STATE OF NORTH CAROLINA  
DEPARTMENT OF TRANSPORTATION

**Addendum No. 1**

RE: Contract ID: C201117  
WBS # 34467.3.7  
Proposal No. 1  
Bladen County (R-2562C)  
NC-87 From NC-131 To  
SR-1191 (Old NC-41).

**December 21, 2004 Letting**

TEMPORARY PAVEMENT DETAIL 4
FROM STA. 180+38 -L-REV TO STA. 186+14 -L-REV (RT)

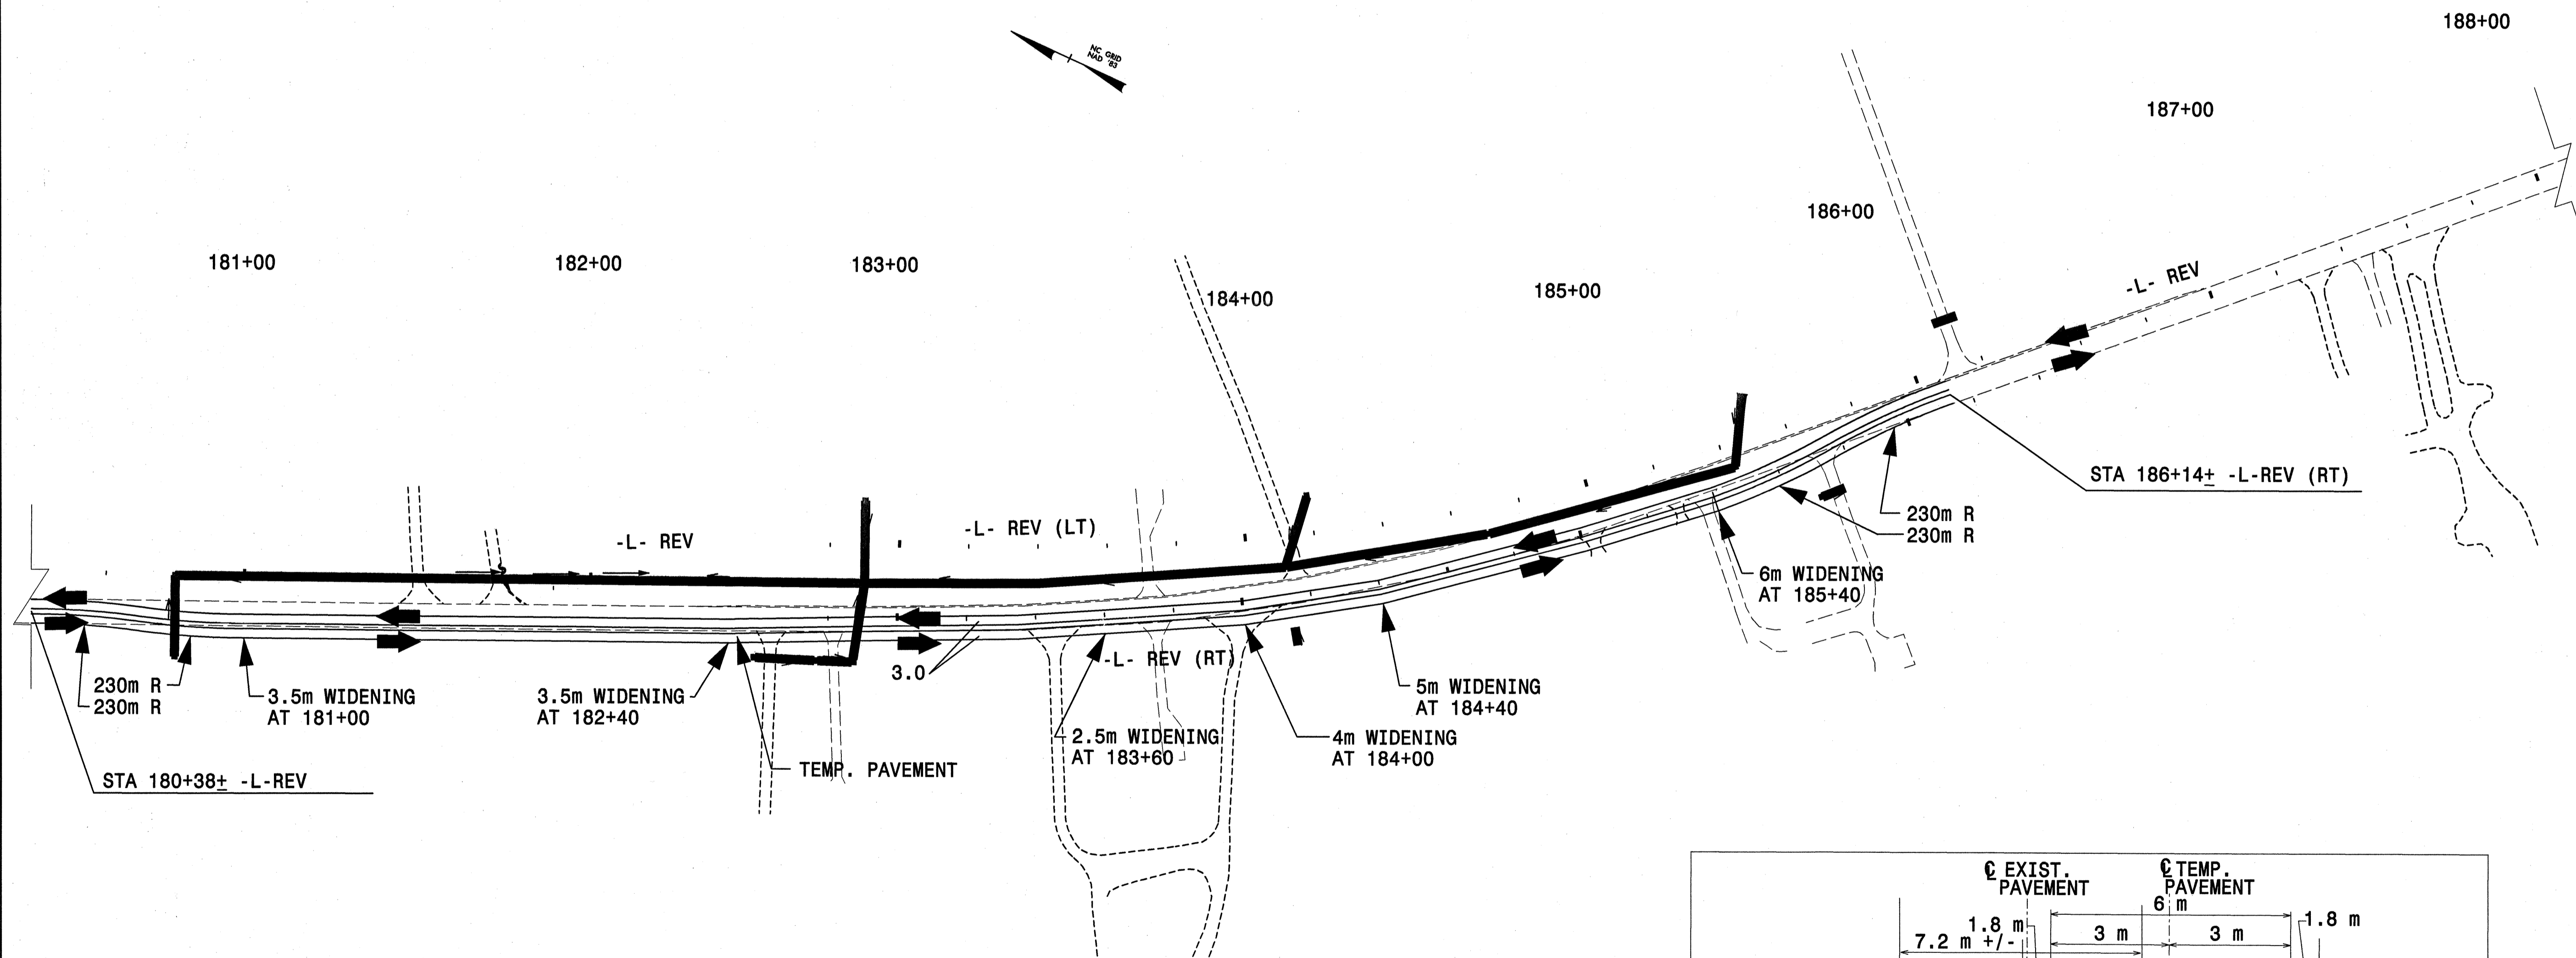
New Sheet Nos. 2-T and 2-U are being added to provide a temporary pavement design. Please staple the new Sheet Nos. 2-T and 2-U after Sheet No. 2-S in your plans.
